Application Ref: H06-0960-21

Proposal: **Proposed glasshouse containing hydroponic growing system, glasshouse annex containing seeding & germination processes, main pack building, admin & welfare building, main plant room, external roads & hardstandings and landscaping.**

Location: **Norfolk House Farm, Main Road, Gedney Drove End, Spalding, PE12 9PB**

Date: 26th October 2021

Figure 4 Proposed Site Entrance

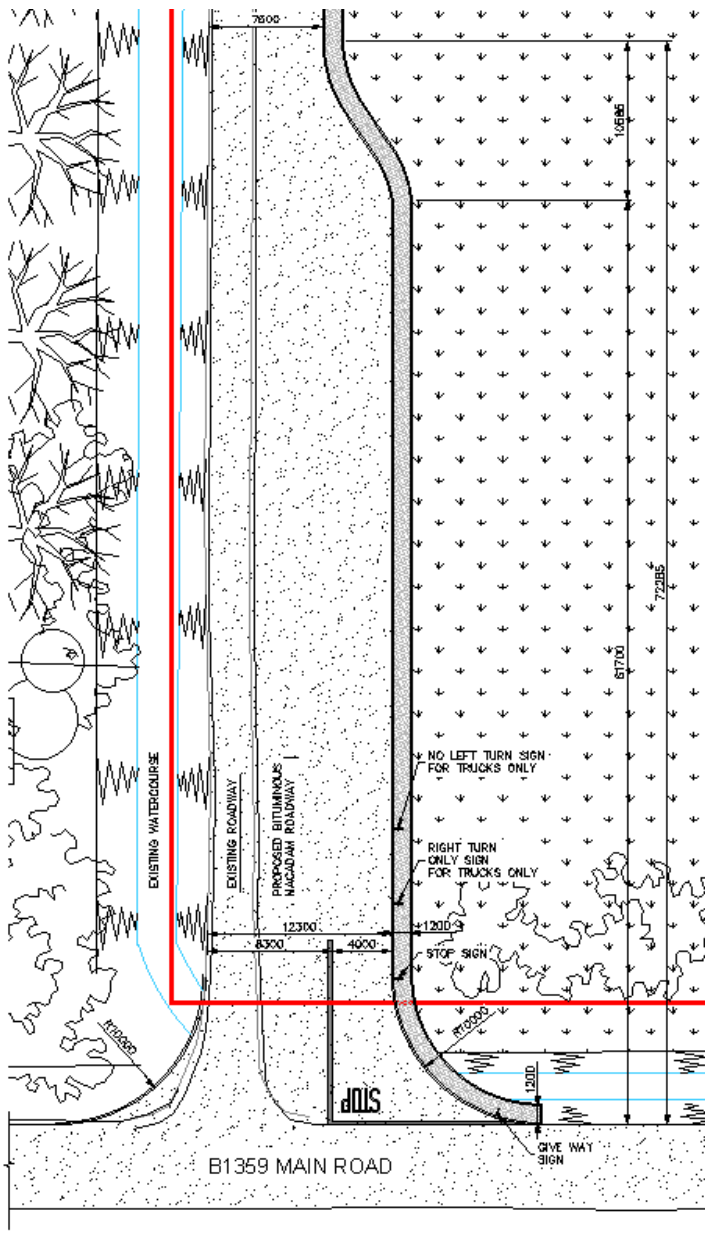
The applicant would also clearly need to demonstrate by providing a swept path analysis, that the proposed upgrade of the existing access by widening the internal roadway to accept two-way traffic and to improve the turning radii onto the main B1359 is acceptable to accommodate HGV movements.
